Item No. **Report of the Head of Planning, Transportation and Regeneration**

Address 4 HARVIL ROAD ICKENHAM

Development: Two storey side and rear extension; raising of main roof ridge; and alteration to windows on front elevation

LBH Ref Nos: **76195/APP/2021/4423**

PROPOSED GROUND FLOOR PLAN
1:100

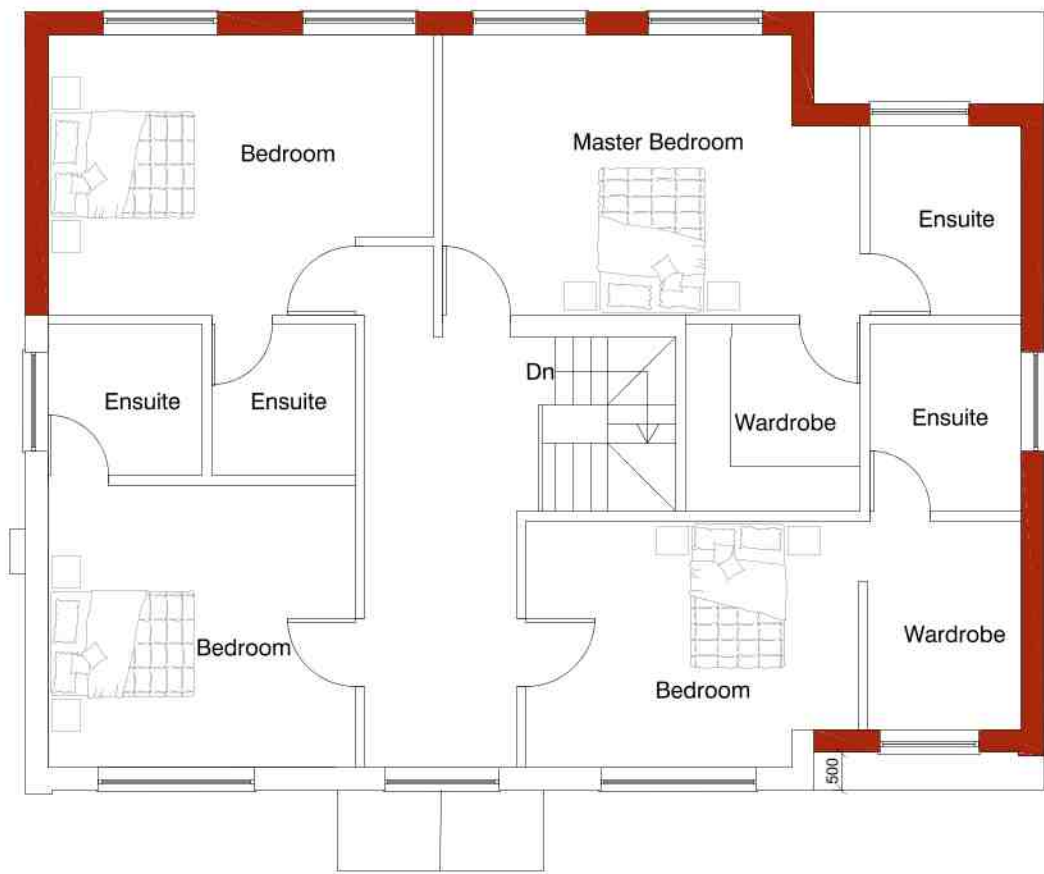
The proposed two storey side/rear extension would be set back from the front elevation of the dwelling by 1 metre and the width of the two storey side element along the front

elevation would not be too wide. However, the proposed two storey side extension would connect to a full width two storey rear extension to form a two storey side to rear extension.

This reason for refusal was upheld at appeal. The current proposal seeks to address the Inspector's concerns by setting back the proposed extension and altering the proposed roof profile to a double crown (which will be addressed below) but a key element of the proposal's unacceptability is the extension's lack of subordination. The extensions have been increased overall in terms of footprint when compared to the appeal scheme.

PROPOSED SIDE ELEVATION
1:100

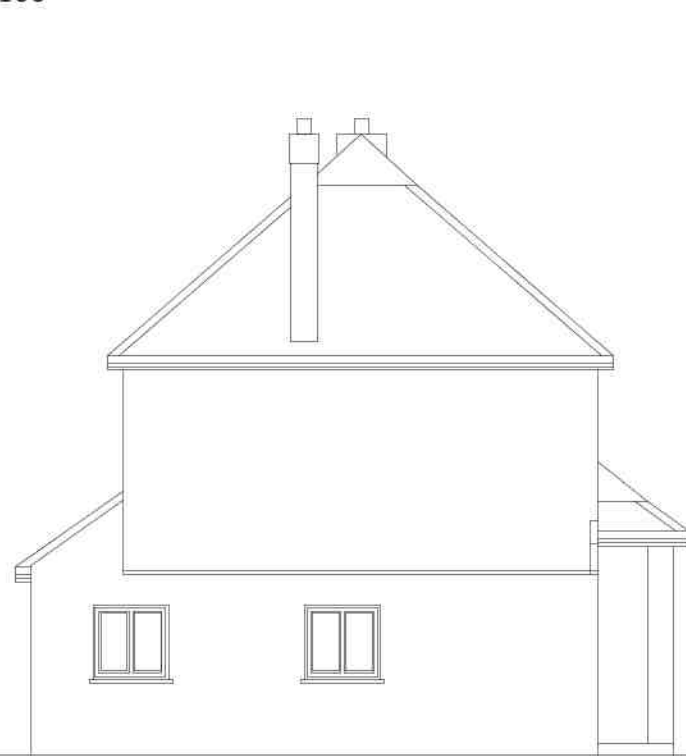
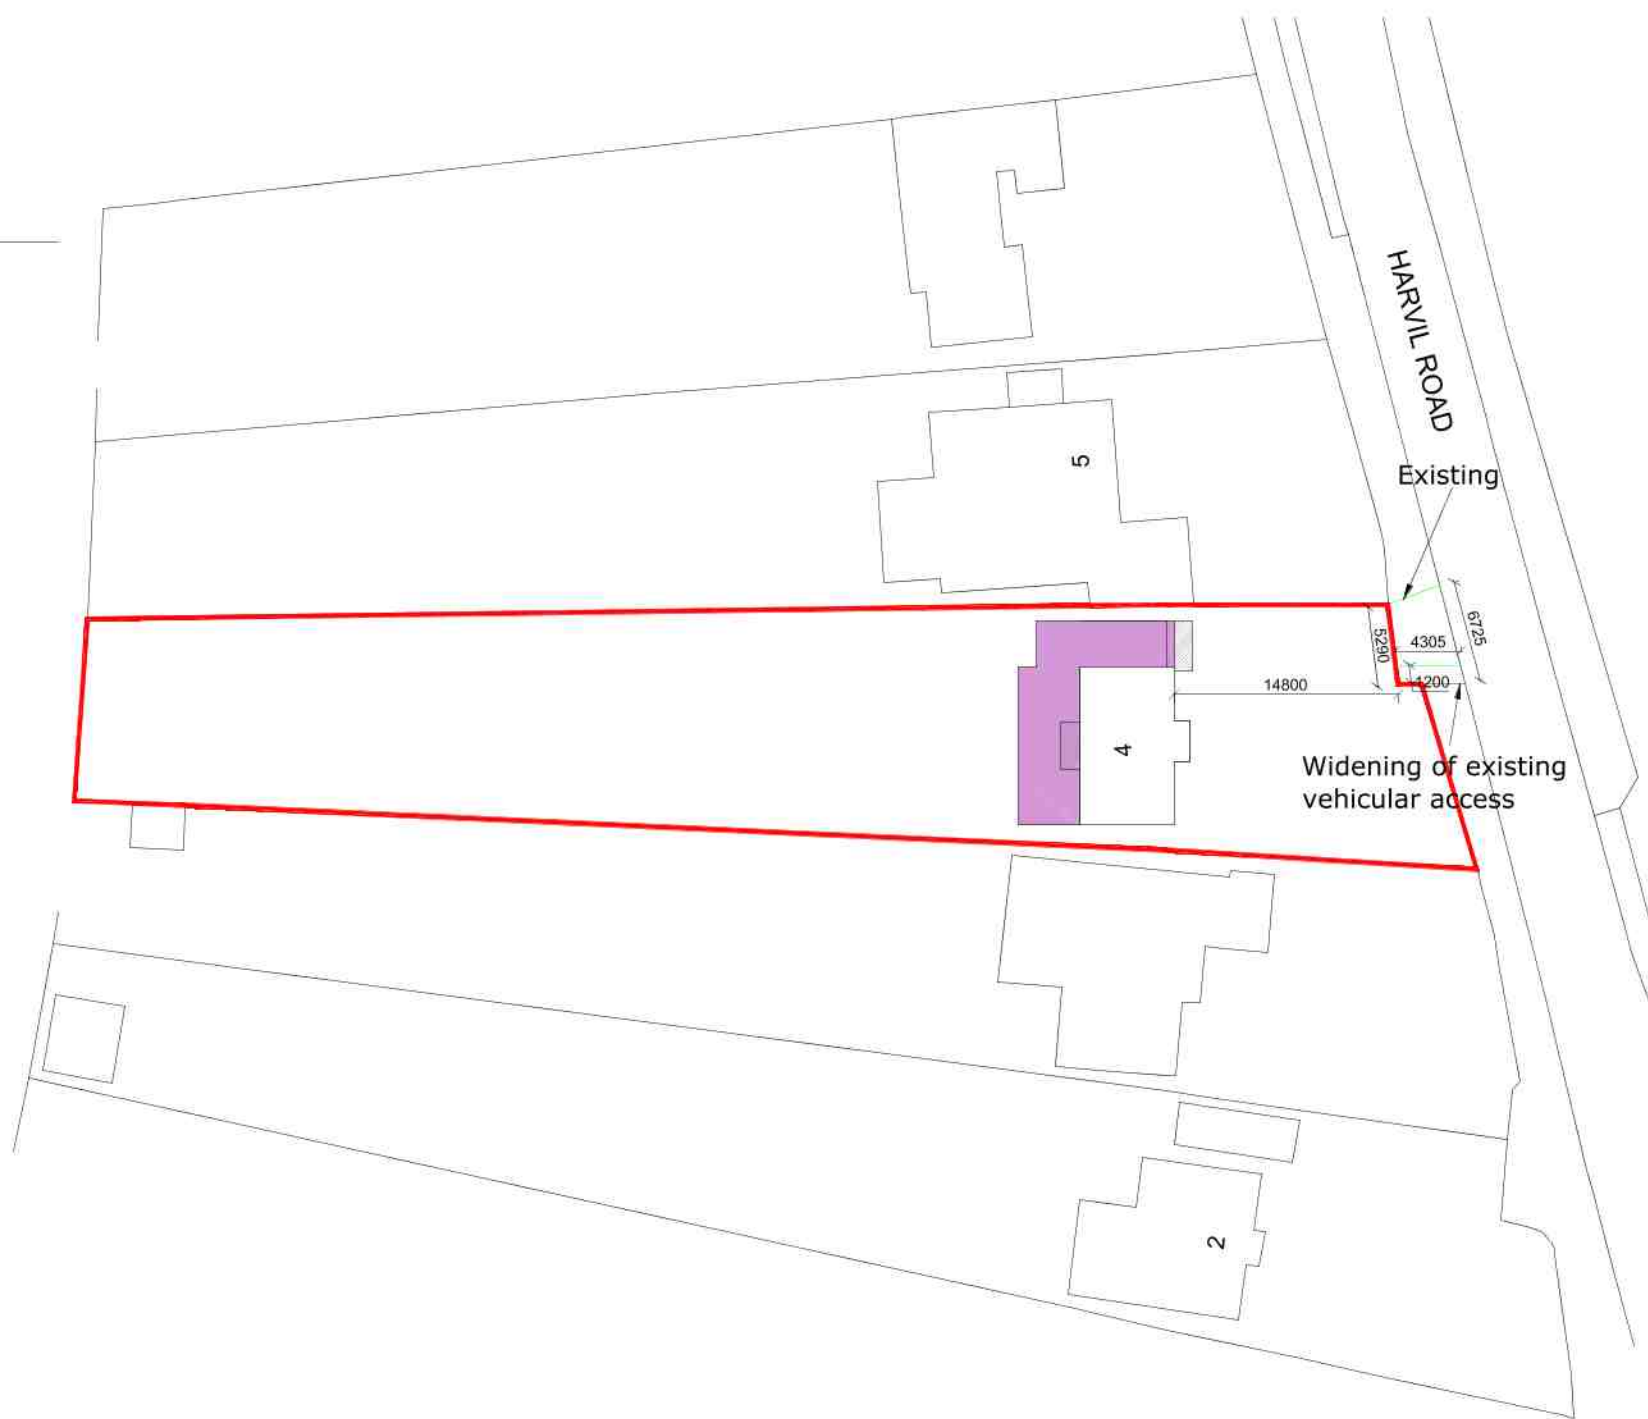
Compared to the previous scheme, the current proposal would increase the size of the two storey depth to the rear (to 5 metres) creating a flank two storey elevation in a prominent location with a depth of 10.2 metres which is considered not be subordinate to the scale or form of the original dwelling. This proposed depth would also increase the scale of the roof alterations proposed. The two crown roofs which would be created would result in additional bulk and mass over and above the scheme considered at appeal which further contributes to the lack of subordination of the proposed extensions.

It is therefore considered that the proposed two storey side to rear extension would be a considerable change to the character and appearance of the existing property which would fail to appear subordinate to the original property. This would impact unduly on the character and appearance of the existing and adjoining properties and the visual amenities of the street scene and the area in general. Therefore, the development is considered unacceptable as it fails to comply with the requirements of Policies DMHD 1, DMHB 11 and 12 of the Local Plan: Part Two - Development Management Policies (2020)

The proposed two storey side to rear extension, by virtue of its siting, depth, size, scale, bulk and design would fail to appear as a subordinate addition and would thus be detrimental to the appearance of the original house, the visual amenities of the street scene and the character and appearance of the wider area. The proposal is therefore contrary to Policy BE1 of the Hillingdon Local Plan: Part One - Strategic Policies (November 2012) and Policies DMHB 11, DMHB 12 and DMHD 1 of the Hillingdon Local Plan: Part Two - Development Management Policies (January 2020).
